CITY OF ALBUQUERQUE

January 10, 2023

**RE: Golf Course & Westside Commercial Subdivision
10850 Golf Course R. NW
Grading Plan and Drainage Report
Engineer's Stamp Date: 11/16/22
Hydrology File: A12D008B2**

Based upon the information provided in your submittal received on 11/17/2022, the Grading & Drainage Plan and Drainage Report cannot be approved for Preliminary Plat, Grading Permit, or Work Order until the following comments are addressed.

Figure 5 – Developed Basin Map

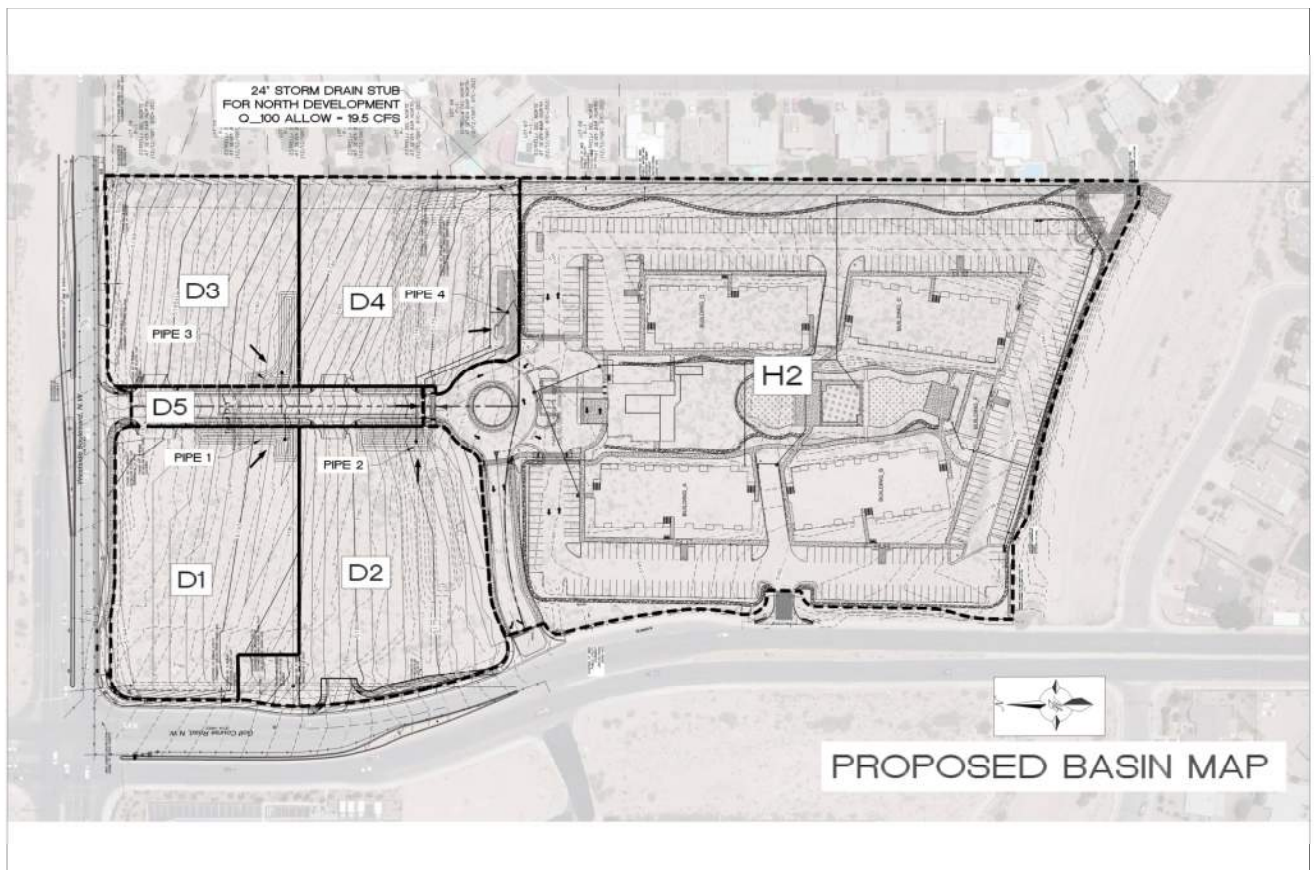
6. Since this subdivision grading will fill in the existing ponds that currently protect the downstream property, provide a Grading Plan and Drainage Report for the infrastructure and grading to be constructed with this subdivision that ensures no increase in surface flows to the downstream property. As indicated by the grading plan, significantly larger portions of lots D-1-A, D-1-B, and D-1-C drain past the ponds on those lots than is indicated on the Basin Map. The subdivision grading now should accomplish the basin boundaries intended as the Masterplan Basin Boundaries and prevent excess cross-lot drainage.

\\TWS\AS\Z\_Drive\2022\2022055 Golf Course & Westside Blvd\dwg\EP\2022055\_GRB.dwg Nov 16, 2022 -- 1:27pm

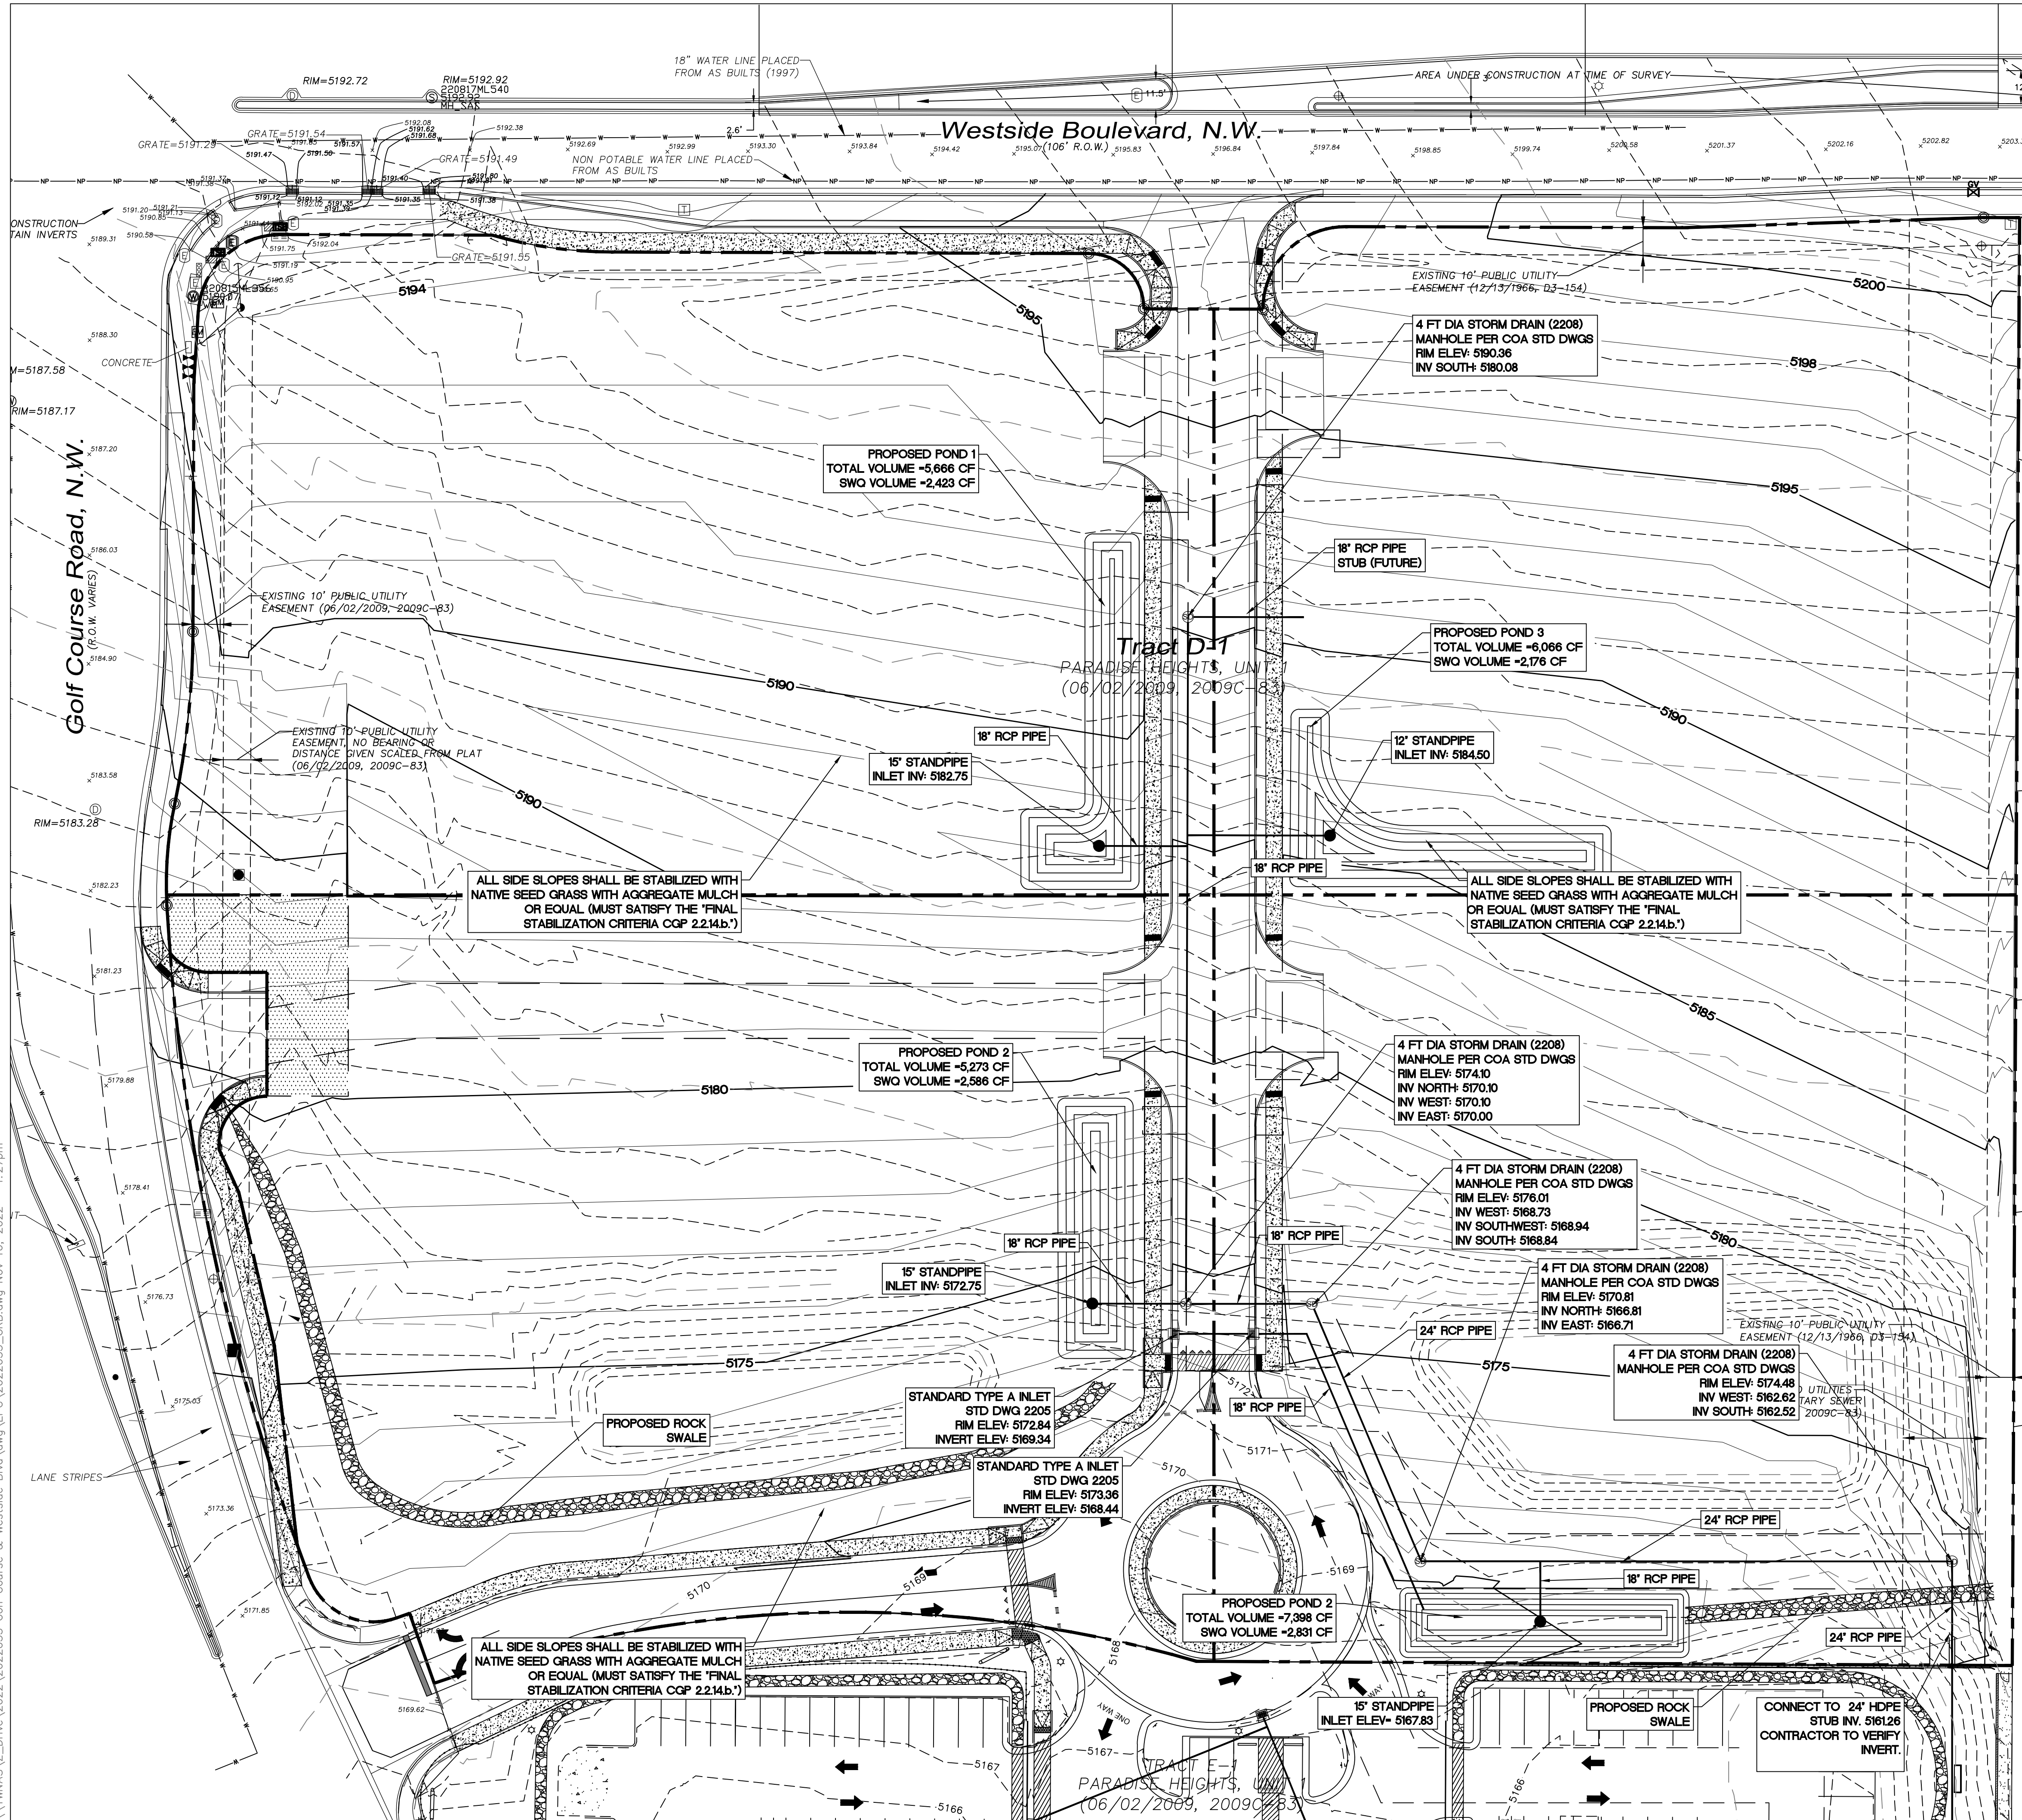
1. The owner information is required on the DTIS form.
2. Remove the word "Conceptual" from the title of the G&D Plan. Conceptual G&D Plans are "Not for Construction," but this plan must show the actual grading and drainage construction that will occur now for this subdivision.

3. Please provide the Benchmark information on the grading plan (location, description, and elevation) for the survey contour information provided. AGRS monument is mentioned on the topo survey in the report, but the location and description are missing. This information is required on all Grading Plans.

4. The legal description and Vicinity map must be included on the Grading Plan.
5. The existing "Blanket Cross Access and Drainage Easement between Tracts D-1 and E-1", granted on the plat recorded on 6/2/2009 in Book 2009C Page 0083, should be replaced with Drainage Easements in the specific locations of all cross-lot drainage both surface and subsurface. Show the easements on the Grading Plan.

7. Typical sections are required on the G&D Plan.
 - a. Show the proximity of walls and slopes to the lot lines and the maximum heights and slopes of each. The grades indicate that a retaining wall is needed between Tracts D-1-A and D-1-D.

- b. The private road section shown on the Grading Plan must include the specification of the curb type as 8" Std C&G per DWG 2415A and the Landscape Buffer Swale per DWG 2414. The 6" dimension on the section should be changed to 7.5" per the detail. The gutter depression needs to be corrected in the street hydraulic calculations from 0.96" to 1.5" (0.08' to 0.125') in the report.

- c. Add typical sections of Westside Blvd. specifying cross-slopes, dimensions, C&G Types, and Landscape Buffers. Add a 0.87' water block at the driveway on Westside Blvd per DWG 2426. Verify water block height after considering vertical curves for traffic safety.

8. The locations of retaining walls and the stabilization of slopes must be shown on the Grading Plan.
9. Label the tracts on the G&D Plan.
10. Label the slopes of the roads on the grading plan, especially near inlets.

11. The report doesn't include calculations to show how this subdivision will drain. The calculations are for a hypothetical future development. The Grading Plan shows hypothetical future ponds that don't tie into the grades around them and significant portions of the lots don't drain to the ponds. Revise the plans and report for this subdivision to show what it's the developer will build and provide a narrative description of the Master Drainage Management Plan for Tracts D-1-A, D-1-B, D-1-C, and D-1-D, stating that there will be a pond on each lot sized for retention of the SWQ Volume plus detention of the volume to limit the 100-year peak discharge to 2.67 cfs/acre flow rate. Drainage from this site will go through the ponds and into the storm drain. Oversized ponds may be constructed with this subdivision in anticipation of hypothetical future development.
